Application No: P/6/26/PL
Site Address: Fairhaven Nyetimber Lane Pagham PO21 3JT
Description of works: Construction of 3 No. detached chalet bungalows together with alterations to existing dwelling with the provision of modified access, parking & landscaping. This application is in CIL Zone 4 and is CIL Liable as new dwellings.

Thank you for your internet representation made on 13th March 2026 which has been recorded as an objection with the comments as follows:

Boundary screening and long-term management - T09, T10, H11 (privacy, character, wildlife)

Tree Constraints Plan
Fairhaven, Nyetimber
Lane, Pagham
GS425.Fairhaven.TCP
Version 1.0
12/07/2025
1:200@A1

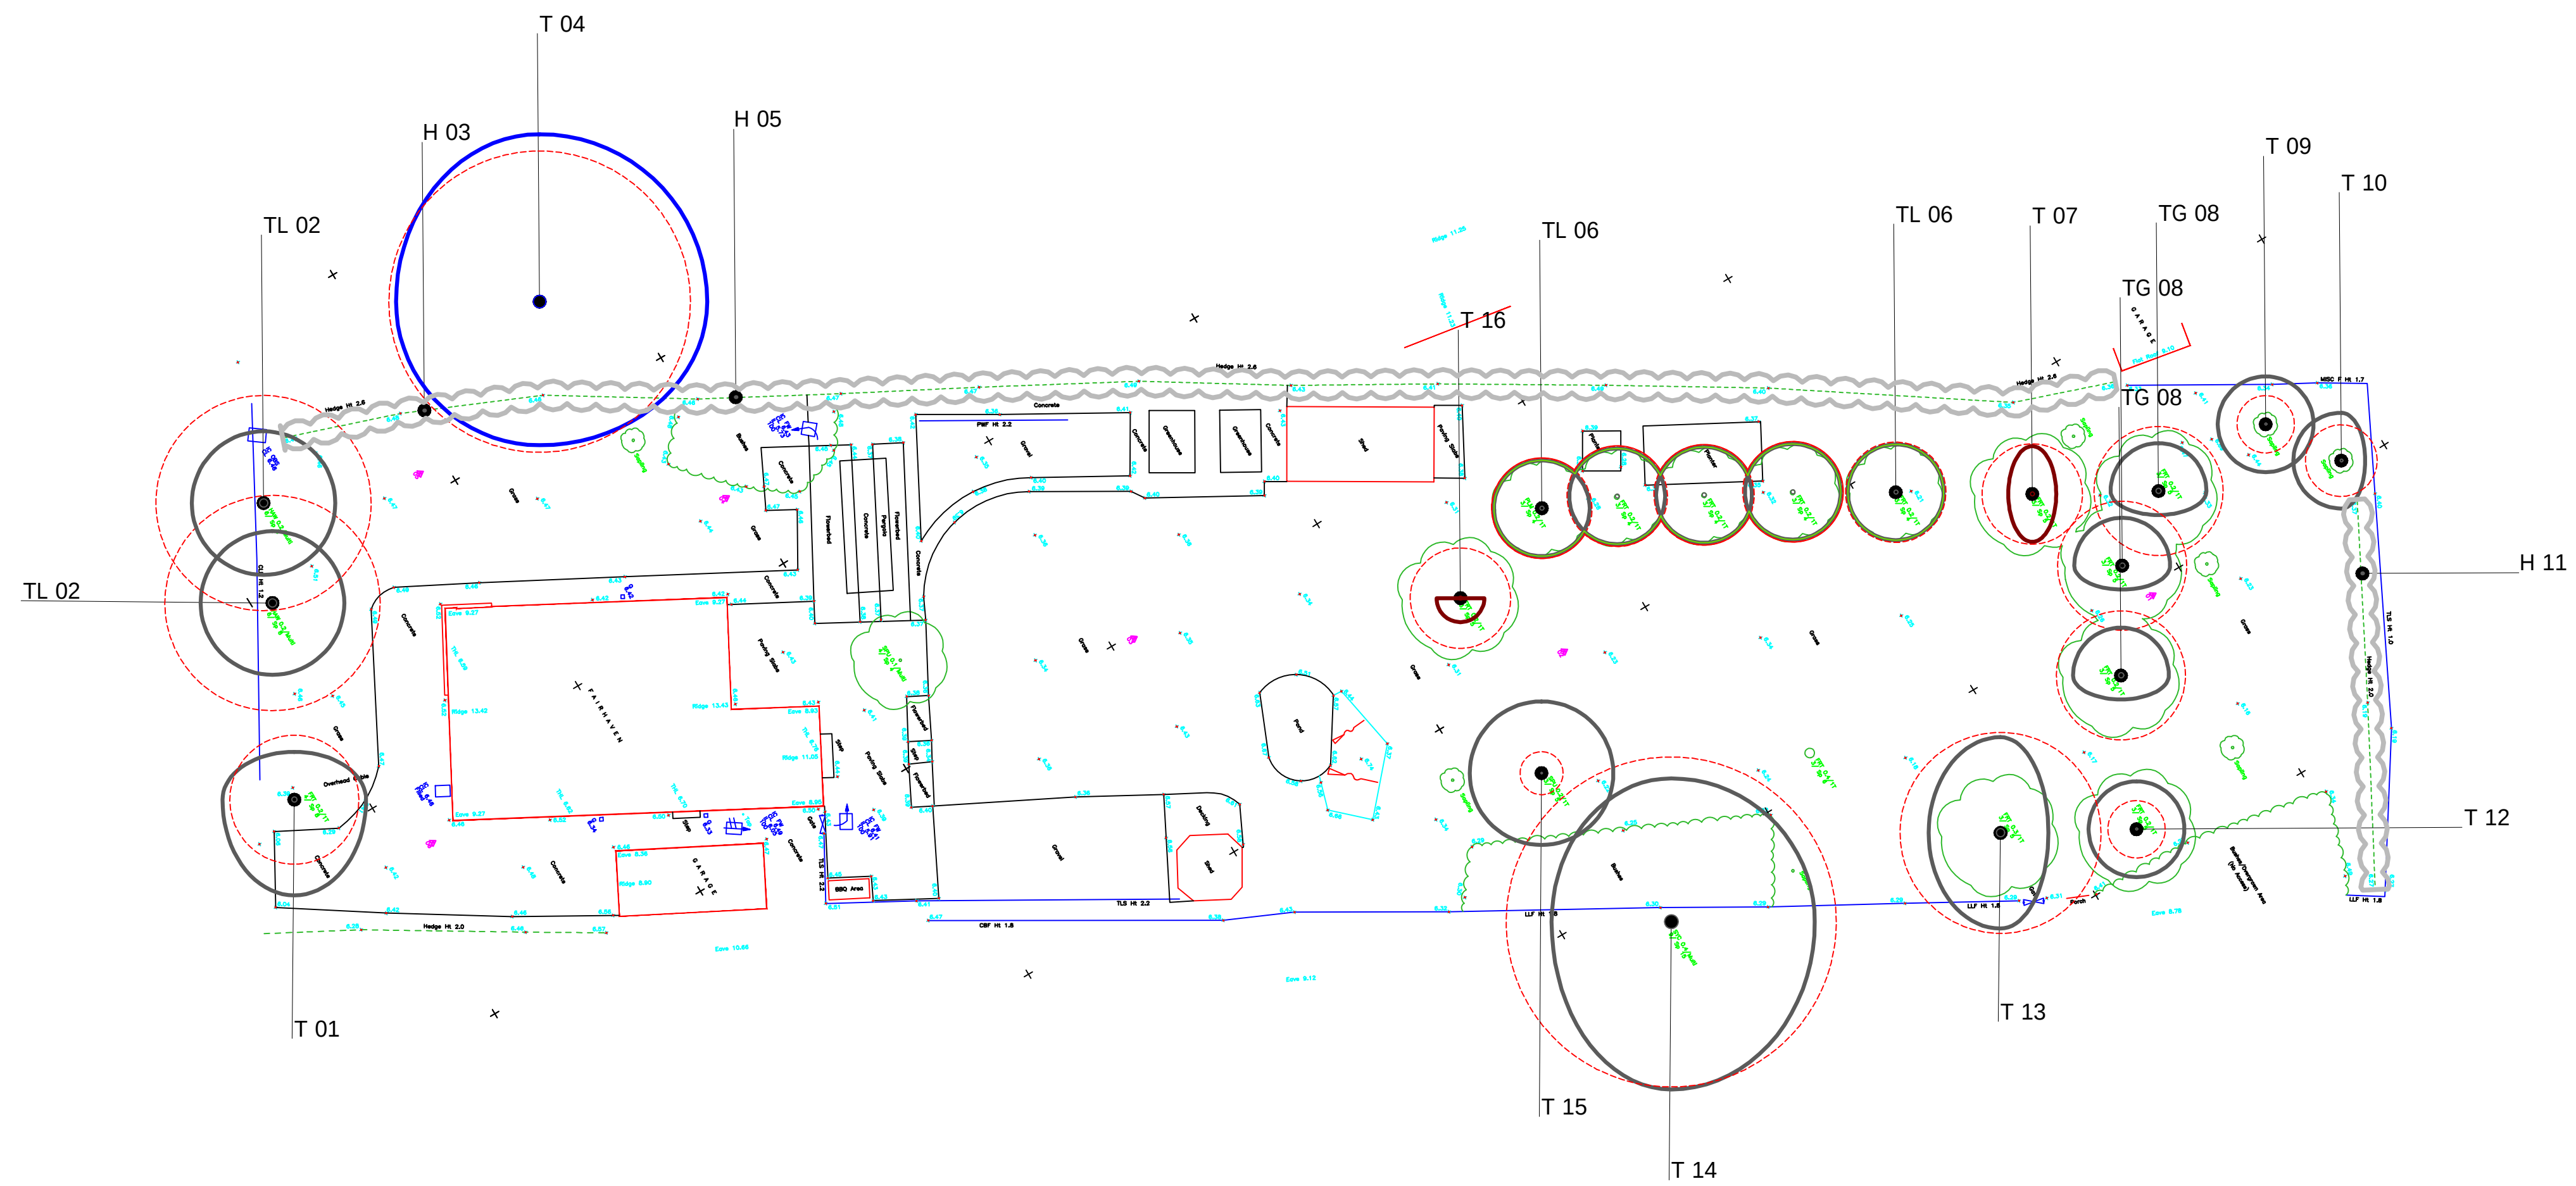
The boundary hedgerow currently provides the primary natural screen between Olive House and the application site and is an established green boundary feature in keeping with the area. It is currently in neglect (not trimmed) and colonised by blackberry which forms dense thorny thickets, spreads rapidly and outcompetes other planting, undermining the quality and manageability of the screen.

Responsibility for maintaining this hedgerow is likely to become fragmented across multiple new owners, increasing the risk of poor maintenance, aggressive cutting or removal. If the hedge is removed or cut too low, the natural screen would be lost and there would be a material increase in overlooking and loss of privacy

between Olive House and the new dwellings' garden/amenity spaces. The hedgerow is also used by wildlife, including birds nesting during the breeding season; removal or unmanaged cutting would harm its habitat value. It should be retained as hedgerow and must not be replaced with close-boarded timber fencing or similar, which would be out of keeping with the local green boundary character.

Retain/protect T09, T10 and H11 with an approved protection plan/method statement;

A Landscape/Boundary Management Plan requiring regular trimming, invasive blackberry control, and replacement of failed sections;

A minimum retained hedge height sufficient to remain an effective screen and protect privacy (to be set by condition);

No removal/replacement of the hedgerow with close-boarded timber fencing or other hard boundary treatments without prior written approval;

Wildlife-sensitive hedge management (avoiding nesting season where practicable);

A legally enforceable mechanism allocating ongoing maintenance responsibility for H11 for the lifetime of the development; and
